*Response to Action Items from RMS Meeting
14th of March 2013*

Royal Randwick Hotel Proposal

April 2013

Design Modification

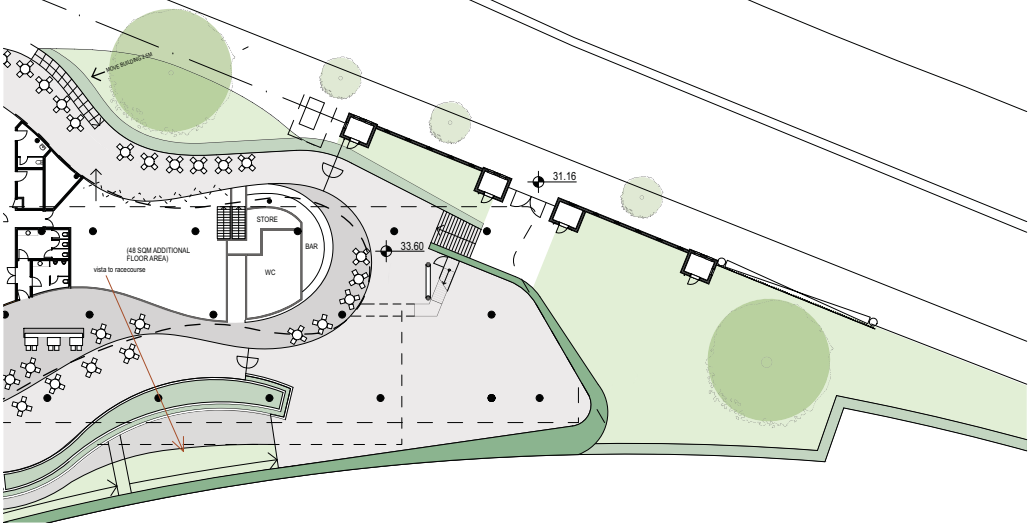
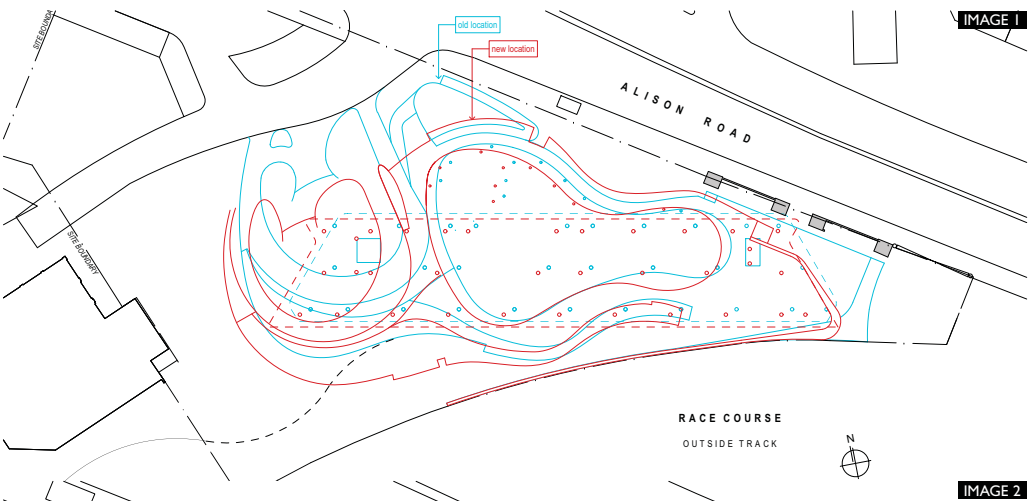
The proximity of the Porte Cochere to Alison Road was raised by Chris Smith. JO advised that the building was being moved 2-3 metres to the south-west and revised plans would be provided.

The hotel scheme has been revised including the slight relocation of the building footprint to the south-west. This has also required an associated relocation of the basement car park ramp and the porte cochere access point, while the footway along the southern edge of the access road has been increase from 4 metres wide to over 11 metres.
